## IMMINGHAM EASTERN RO-RO TERMINAL DCO APPLICATION

### PINS REFERENCE TR030007

#### COMMENTS ON DEADLINE 5 SUBMISSIONS BY DFDS

Drawing number
B2429400-JAC-00-ZZ-DR-ZZ-0201

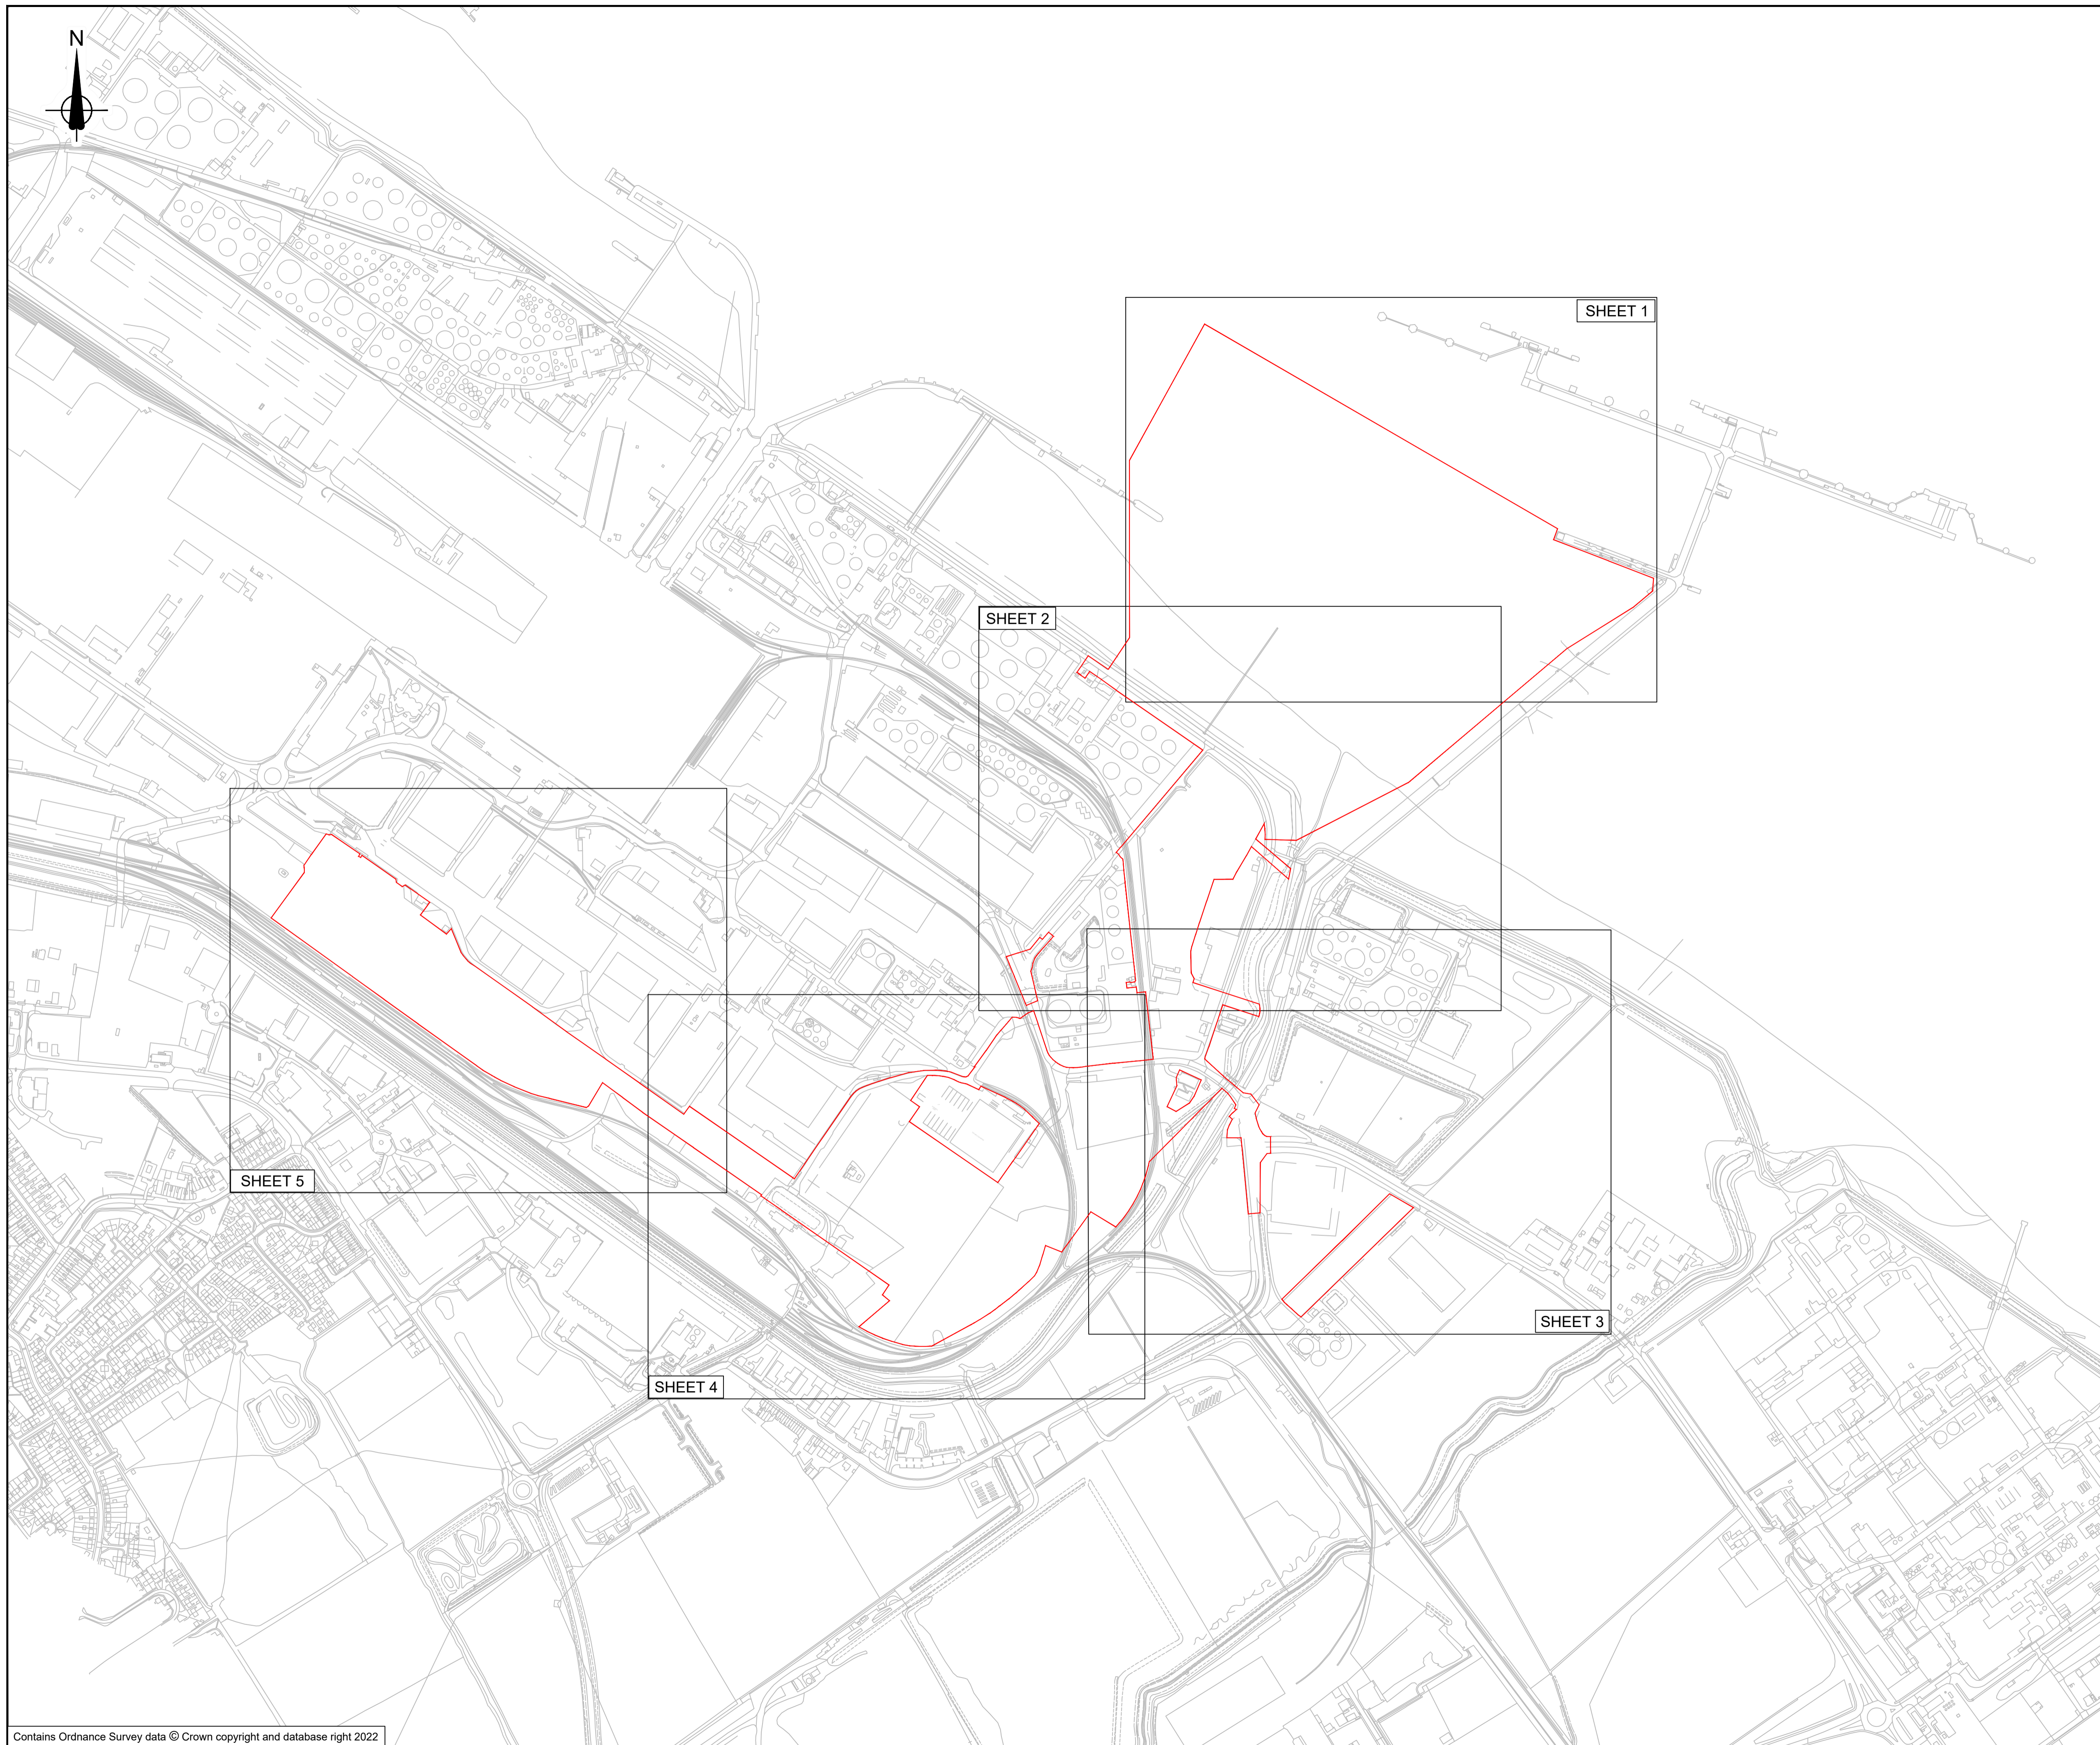
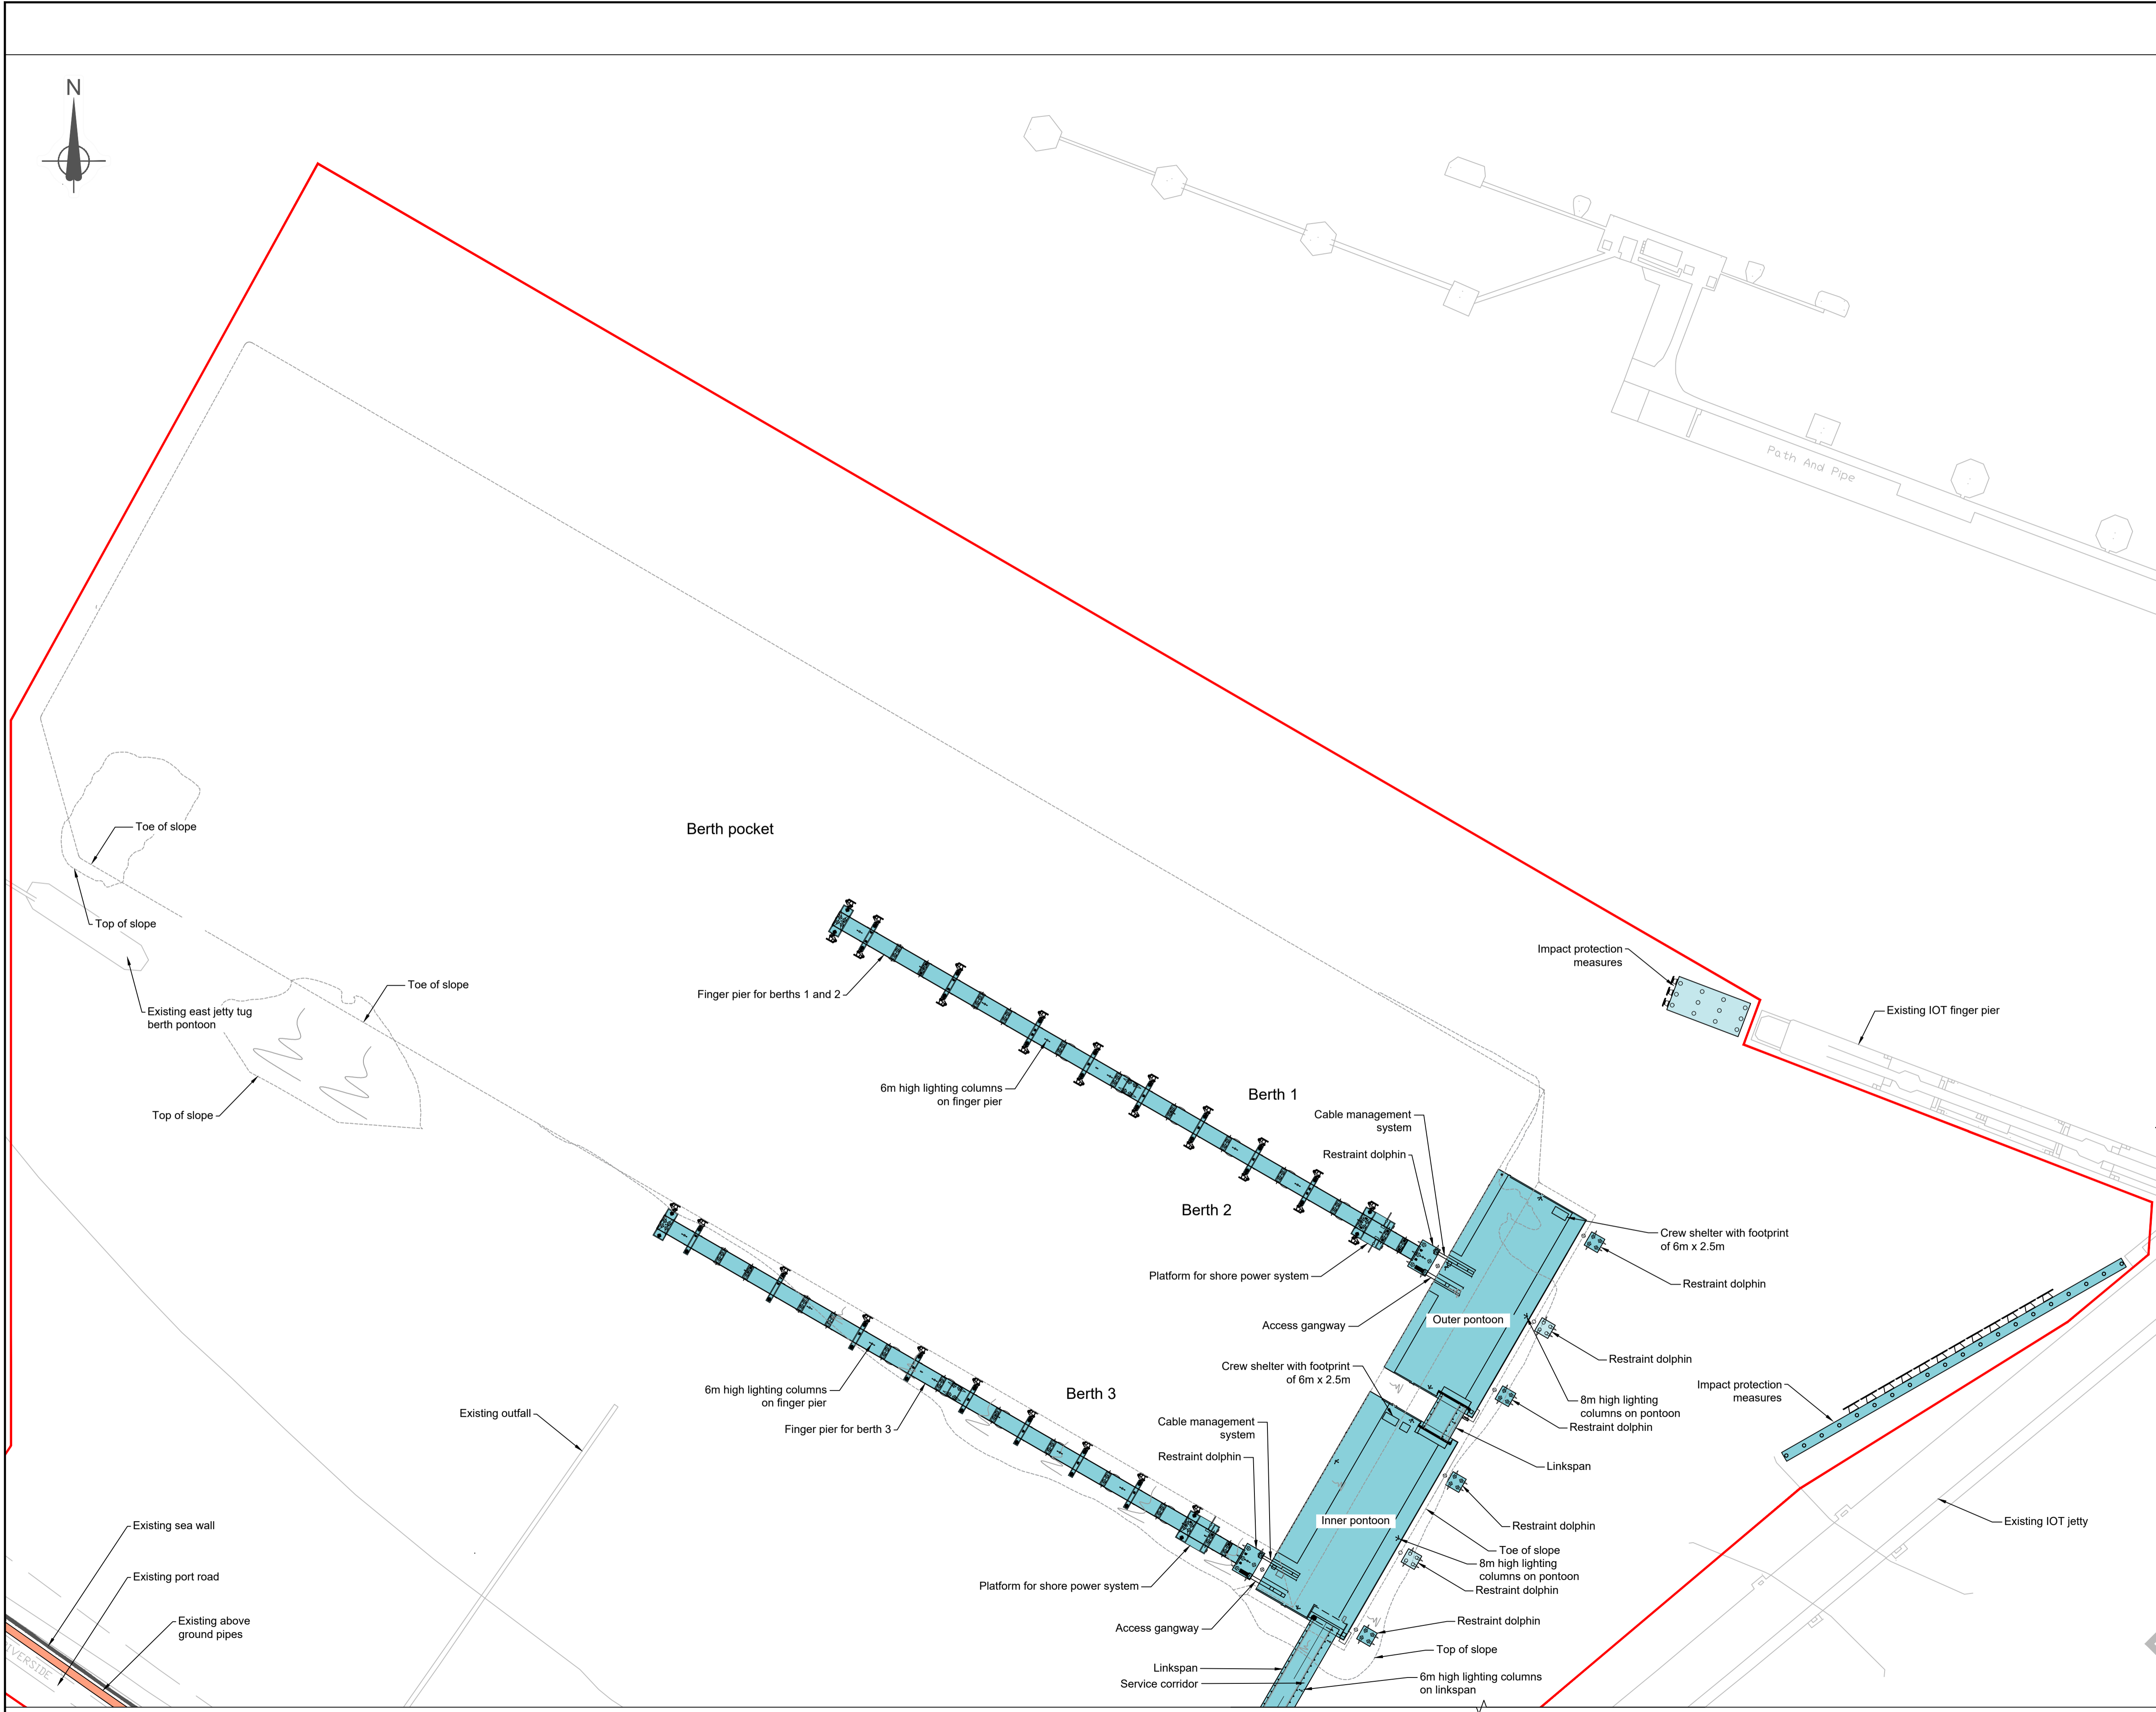
51. The assessment of the East Gate considers that both lanes on the East Gate can be used to enter the port, however details shown on the General Arrangement Plans East Gate & Bridge Regulation 5(2)(o) & 5(2)(k) Sheet 3 of 5 [[AS-029](#)] show that the left hand land is dedicated to cars and vans, whilst the right hand lane is dedicated to HGV's (a screen shot of this is provided in Figure 1 - East Gate Configuration). This would mean that queue capacity for HGV is significantly over represented within the gate house assessment.

52. The Applicant's Transport Consultant indicates that this is not correct and the design will be modified in detail design, however this is contradictory to what is stated in the project drawings.
